From: Michael Eastham
Sent: 31 July 2018 07:58
To: Planning.Responses
Subject: FW: Planning application ref - AL/20/18/OUT

From: [REDACTED]
Sent: 30 July 2018 10:02
To: Sue Howell
Cc: Michael Eastham
Subject: Planning application ref - AL/20/18/OUT

Layout

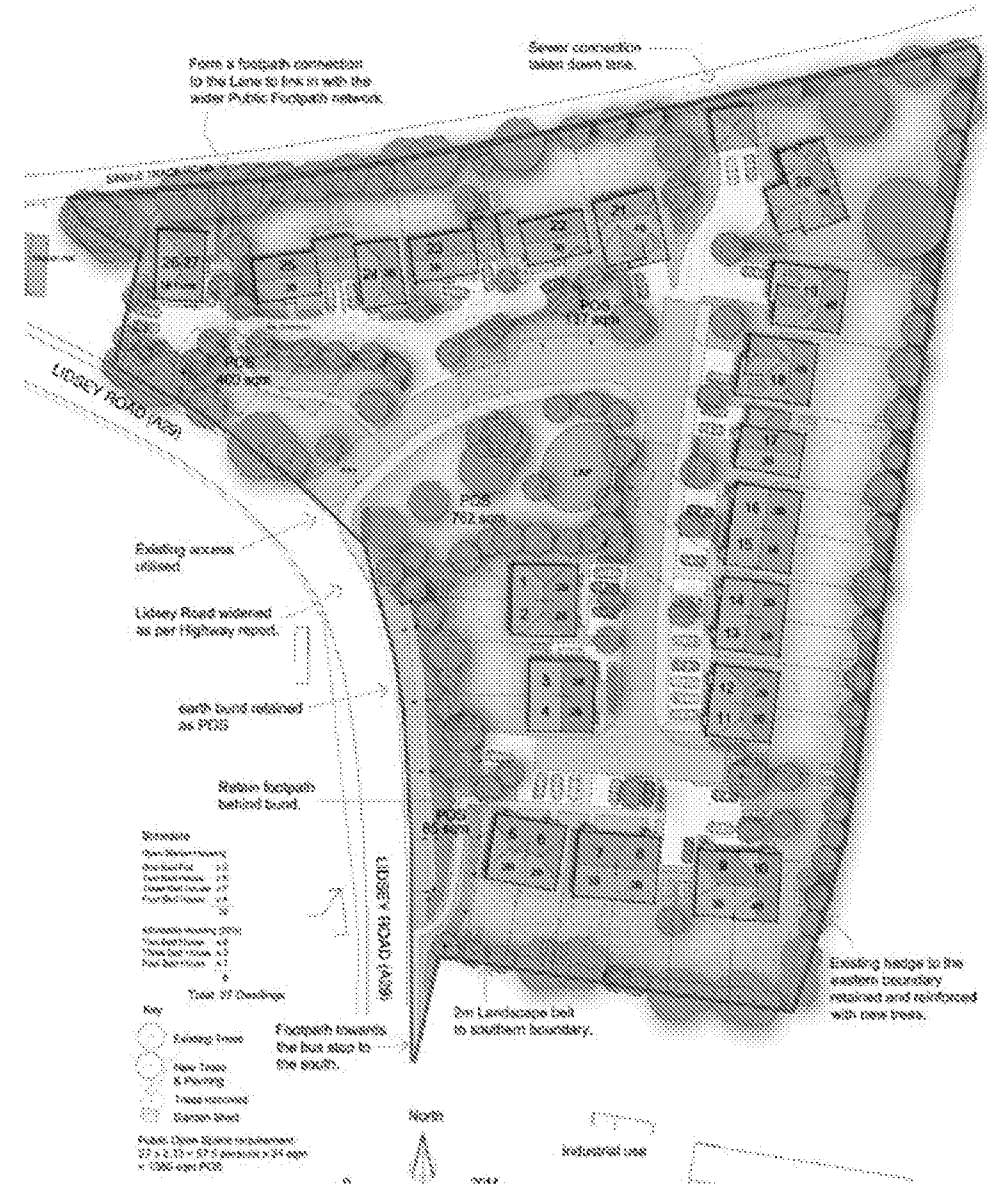
The current open space provision is worked out on the basis of 24 sqm of open space per person, applying the standard set out in the open space SPG. The average household size has been taken from the census at 2.13 people per household. This would produce a requirement of 1380.24sqm, and 1384sqm is therefore proposed. Could you please let me know how you have worked this out differently? Your comments mention higher FIT guidelines but refers to these as being superseded so I am not clear what standards are being applied or if the difference is due to a different household size being applied. The Councils standards are based broadly upon the National Playing Fields Association (NPFA) "Six Acre Standard" SPG (October 2000) Under the superseded Fields in Trust (FIT) Guidelines 'Guidance for Outdoor Sport and Play, Beyond the Six Acre Standard' October 2015 this recommends 32 sqm of open space per person "Quantity guidelines are provided as minimum guidelines and should not be interpreted as maximum levels of provision" Our population figure is estimated on the basis of 2.4 people per dwelling (The figure derived from the 1991 census within our SPG)

Secondly could you please direct me to which standards you are using which set out the thresholds for LEAPs and MUGAs? The SPG applies a 50 dwelling threshold for LEAPs so this was why one is not shown. Could you also please confirm the size of LEAP you require, and if you would require a LAP in addition. As above we are using the Fields in Trust (FIT) Guidelines 'Guidance for Outdoor Sport and Play, Beyond the Six Acre Standard' October 2015 for our play triggers. These state that between 10-200 dwellings the requirement will be for onsite LAP and LEAP and a contribution towards offsite MUGA provision.

LAP 10m x 10m (minimum activity zone 100sqm), natural play, unequipped
LEAP 20 x 20m (minimum activity zone 400sqm) minimum 6 play experiences

A consideration also of any development must be the location and accessibility of available play to the developments location. The adjacent busy road and lack of footpath would strengthen further the requirement that Play provision is provided on-site.
